MAJOR PROJECT ASSESSMENT:
Residential Development Buildings 6, 9 & 10
61 Mobbs Lane, Epping- Former Channel 7 site
MP11_0048

Director-General's
Environmental Assessment Report
Section 75I of the
Environmental Planning and Assessment Act 1979

May 2012

1 BUILDING SEPARATION
1 : 250

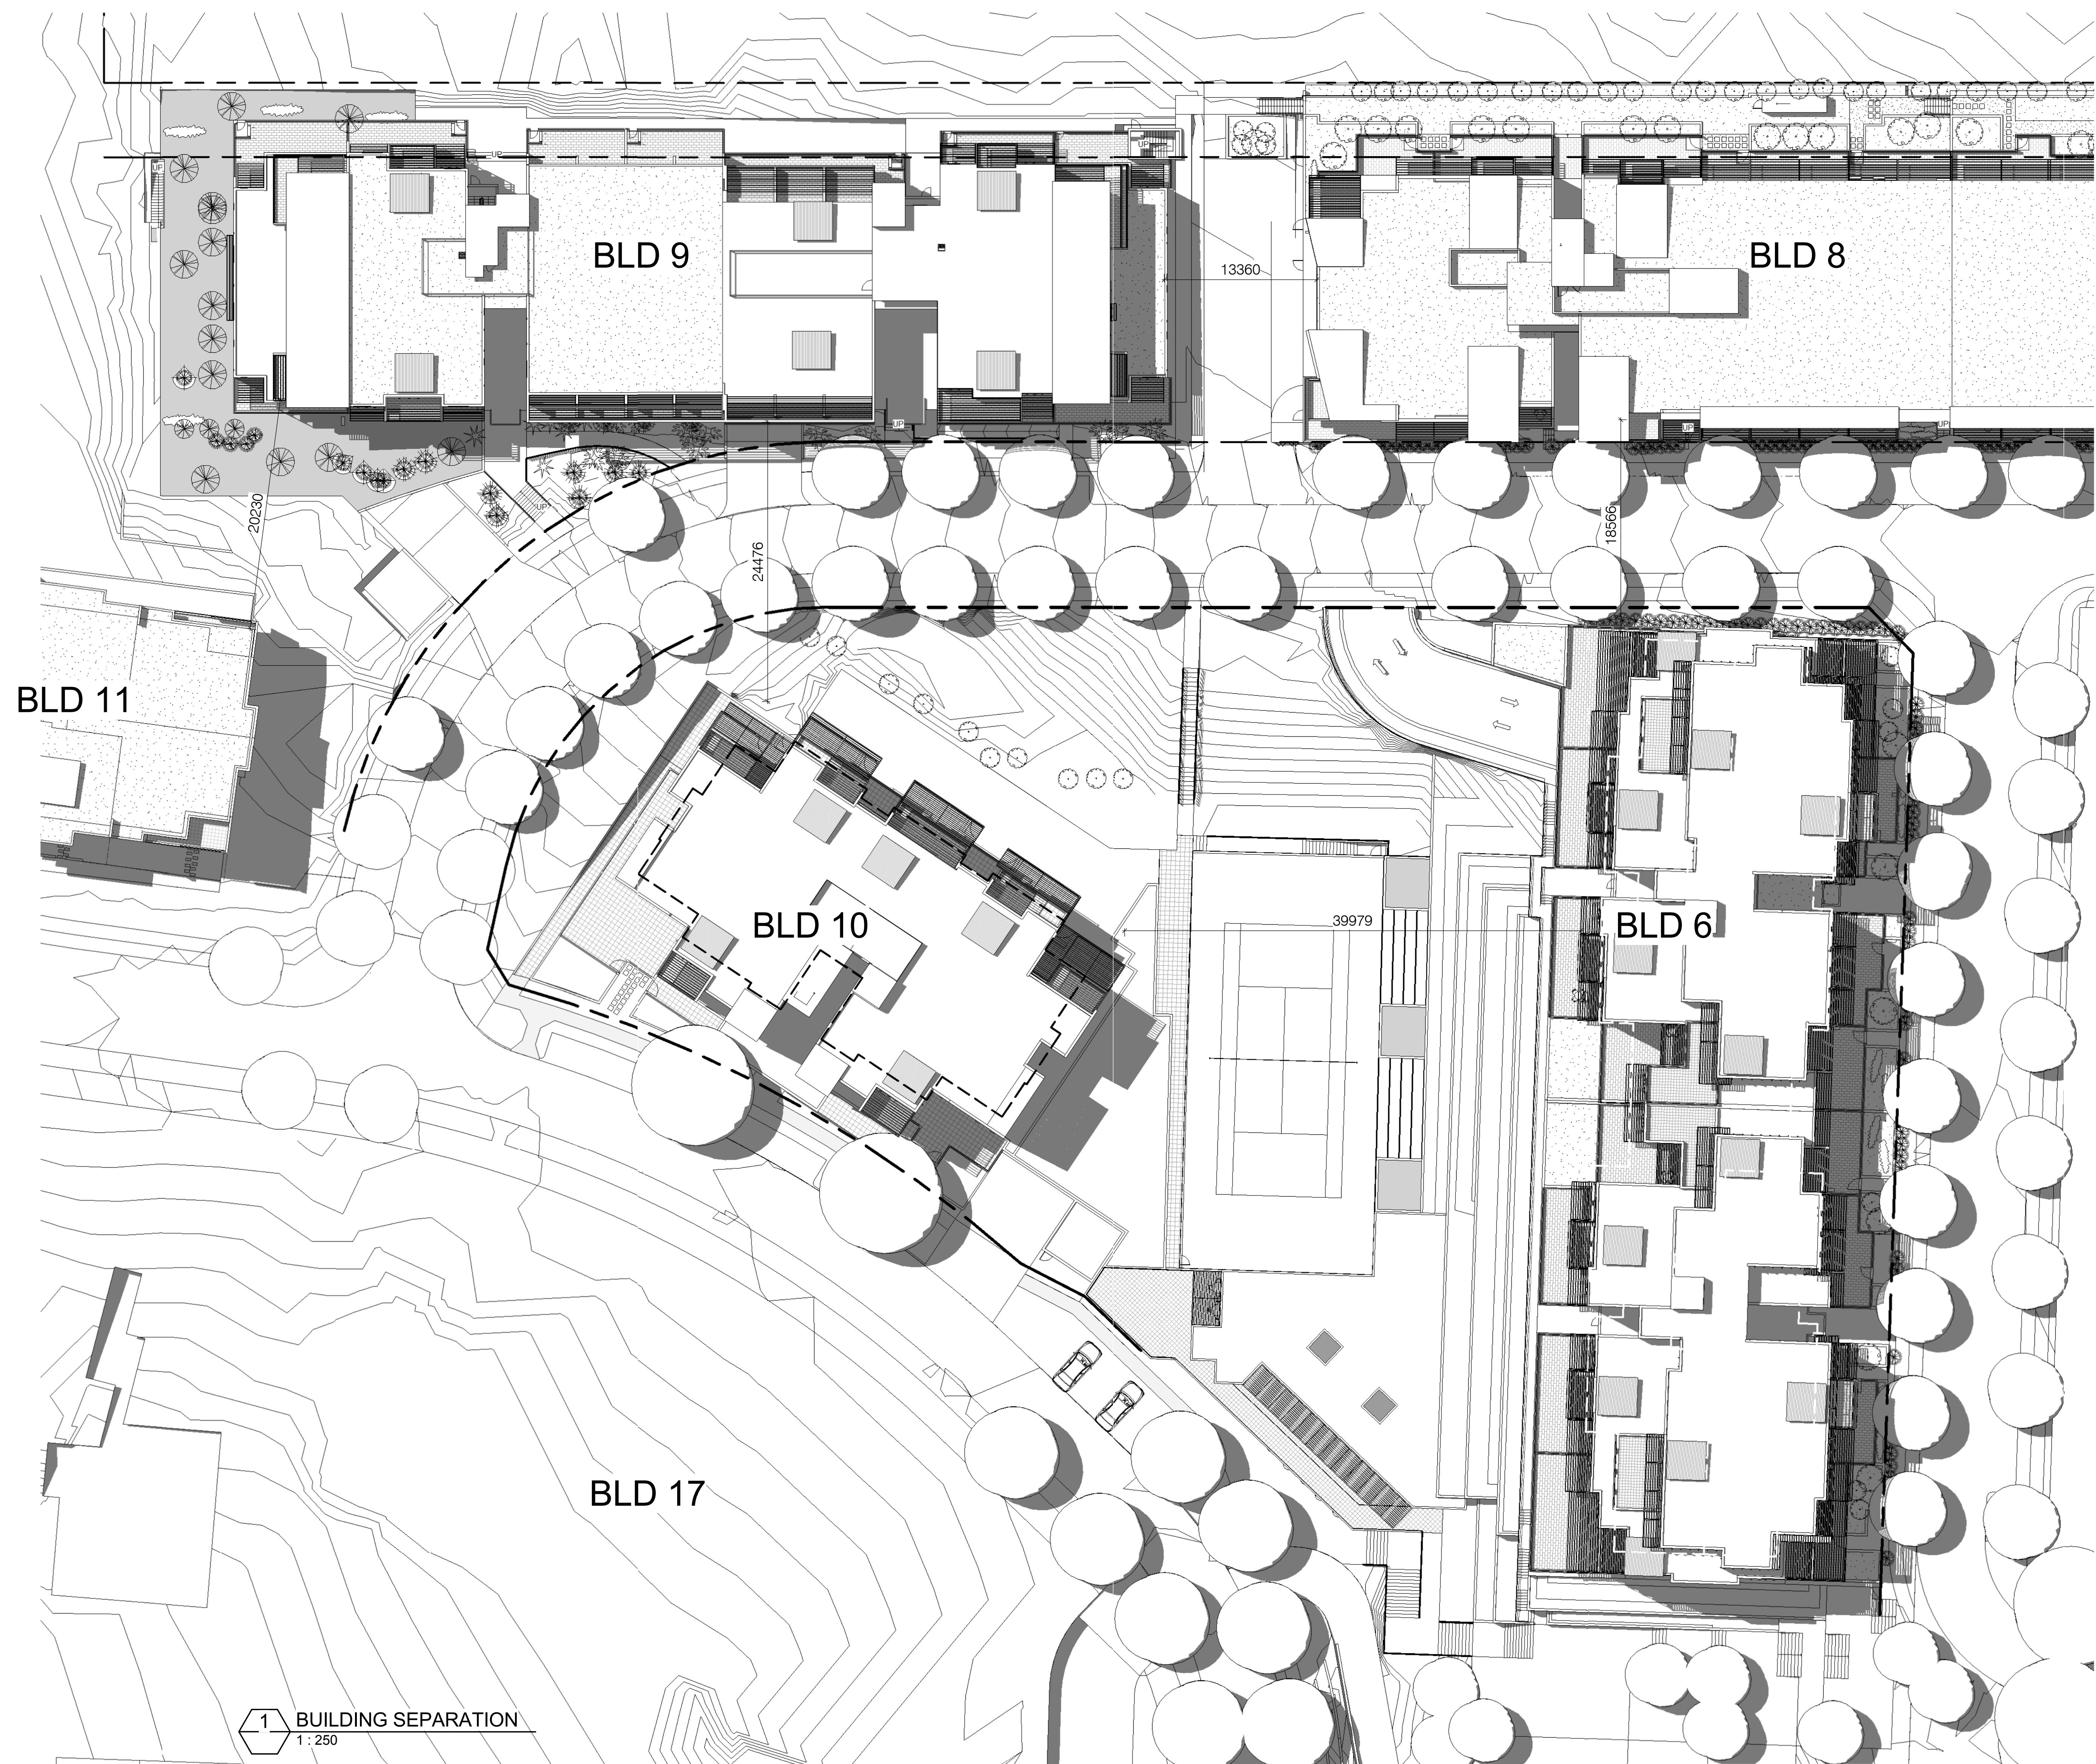
- the provision of an additional 23 basement car spaces (to comply with approved car parking rates)
- the modification of east facing apartments of Building 9 facing Building 8 (to comply with RFDC amenity requirements).
